Ribble Valley Borough Council
Council Offices
Church Walk,
Clitheroe
Lancashire
BB7 2RA

Location: Central Garage Warwick Street Longridge PR3 3EB
Proposal: Proposed industrial unit 59.5m sq behind existing industrial unit of 169m sq.
Grid Ref: 360216 437487

Summary

Central Garage
Warwick Street
Longridge
Parking Layout and
Goods Vehicle Manoeuvres

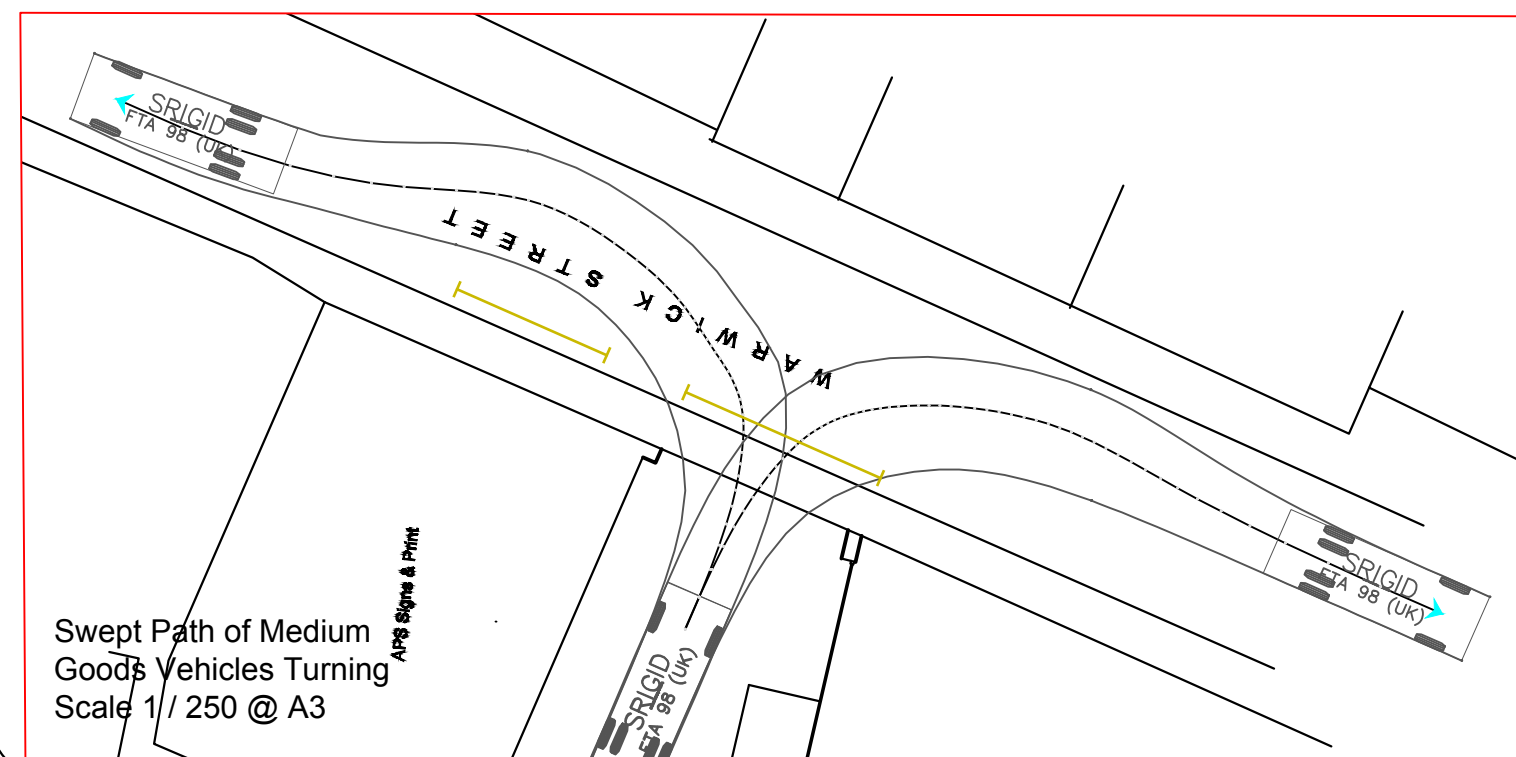
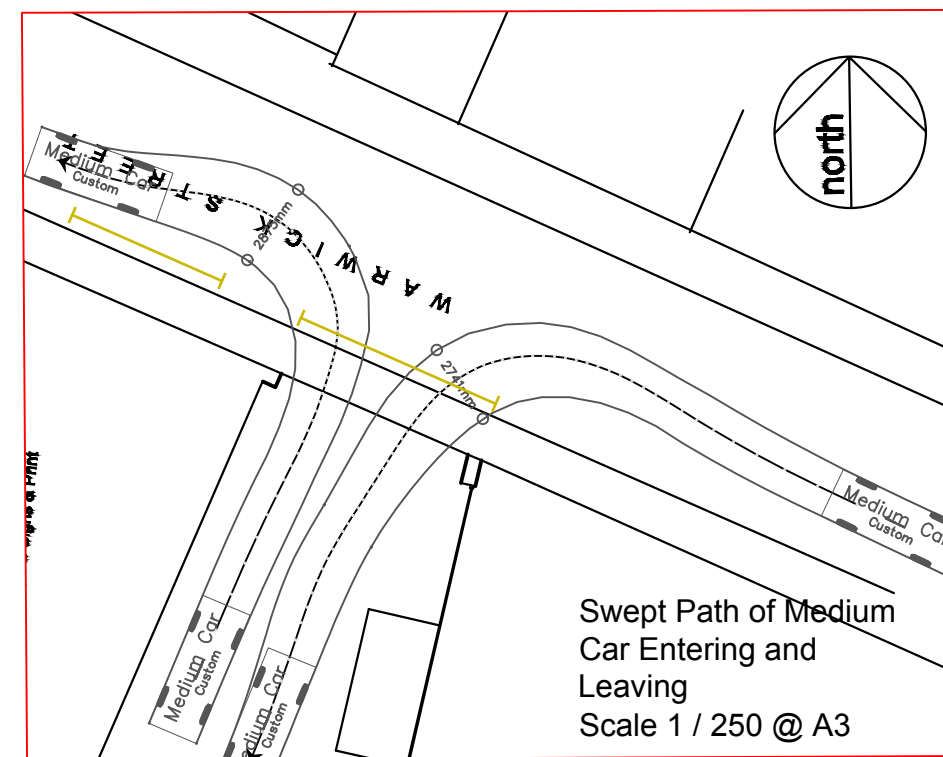
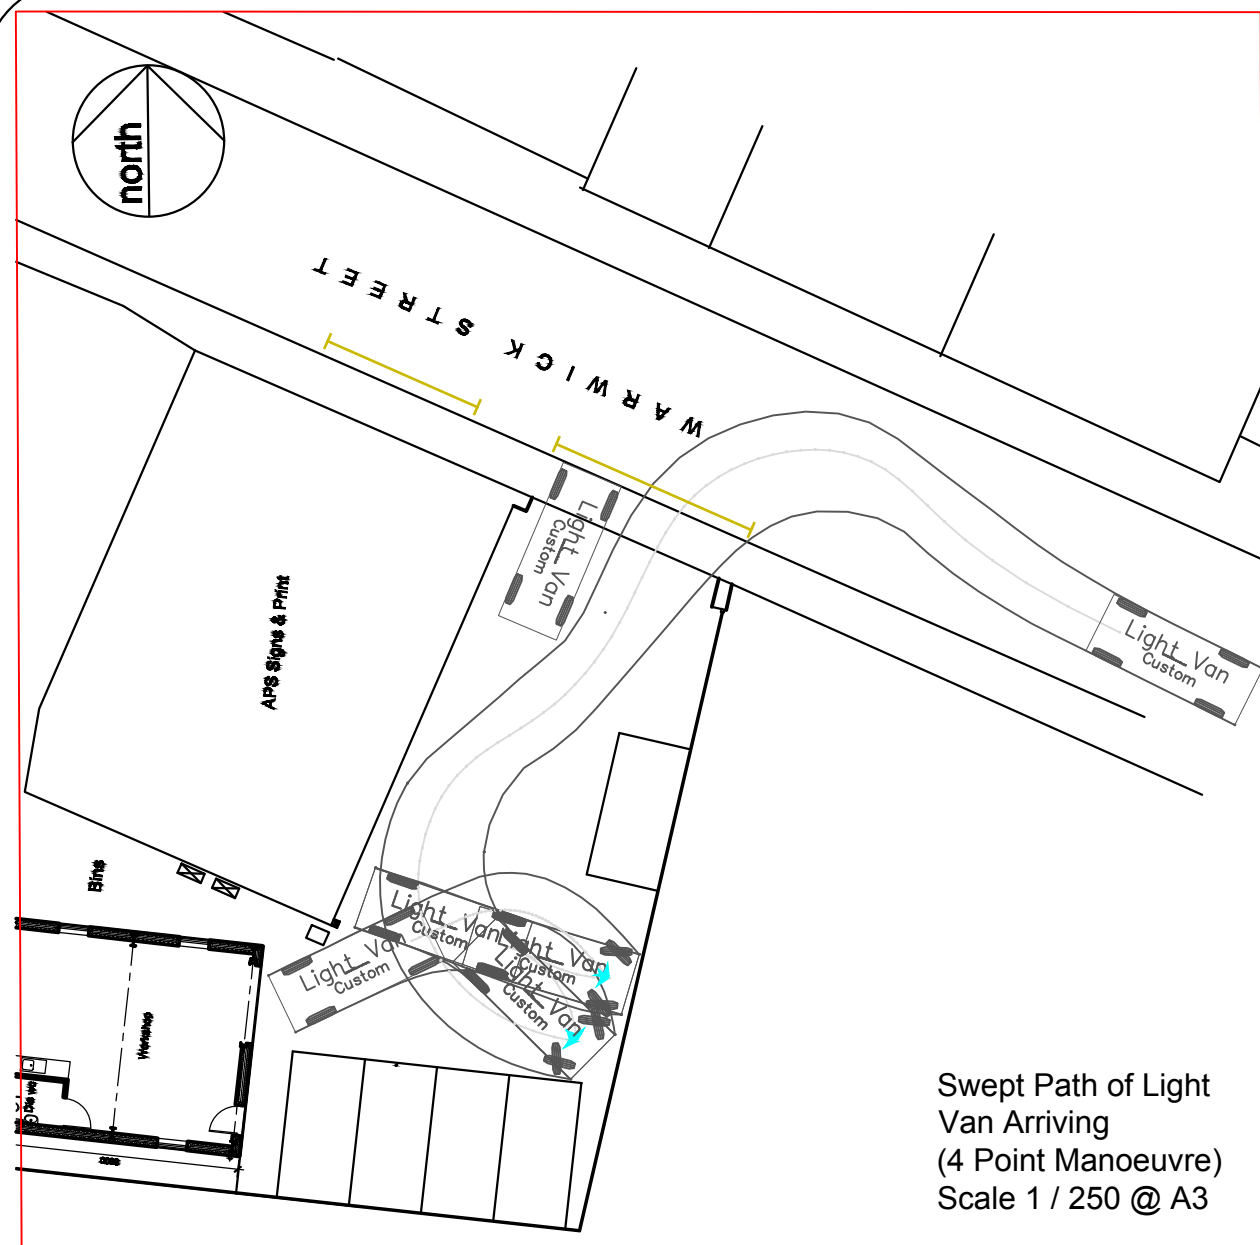
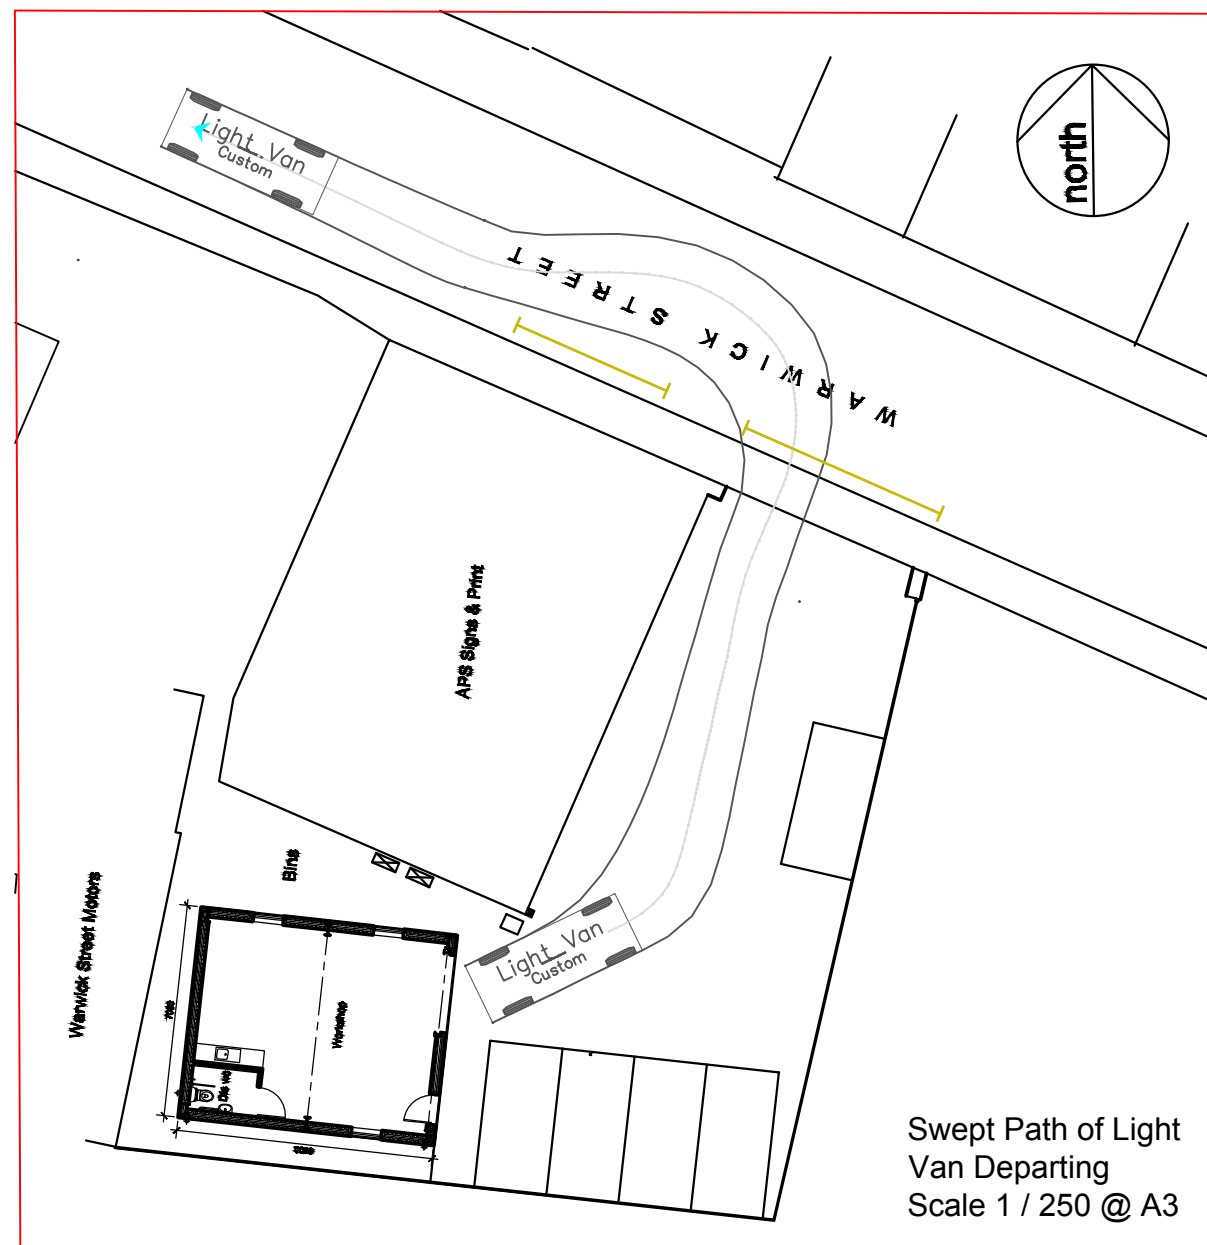
As has previously been addressed the LHA has reviewed the amended drawing number 240901/01 and noted the site has a total of 5 off-street parking spaces, which is acceptable for the size and use class of both the existing unit and proposed unit.

As previously detailed in our response of 7 November 2024, the applicant has stated that deliveries take place in large vans, as represented in the Swept Path Analysis drawing 240901/01. The evidence within the drawings and further details provided by the applicant to date show that turning within the site is not possible for large vans and does not occur.

The LHA are of the opinion that reversing a medium goods vehicle from the live carriageway is not a manoeuvre we would deem safe, particularly in a town centre location with significant on-street parking. This would be to the detriment of highway safety, with vehicles parking on-street not only providing an obstruction to the reversing movement and potentially creating conflict points, but also parked vehicles obstructing the access's visibility splays. This obstruction means that conflicts could occur should other vehicles be using Warwick Street at the same time as the movement. As a result of these potential conflicts, allowing new commercial development to take place within an area that already has known highway safety concerns would be detrimental to highway safety and contrary to Paragraph 114 and Paragraph 115 of the National Planning Policy Framework (2023), which emphasise the need for developments to provide safe and suitable access for all users and to ensure that new development does not harm the safety of the existing road network.

Whilst the applicant has stated that no servicing occurs in the area where the proposed development would take place, the LHA believes that this space could provide adequate servicing for the existing site. Given the safety concerns associated with servicing from the carriageway, the LHA is of the opinion that this area should be kept clear to allow for safe servicing operations.
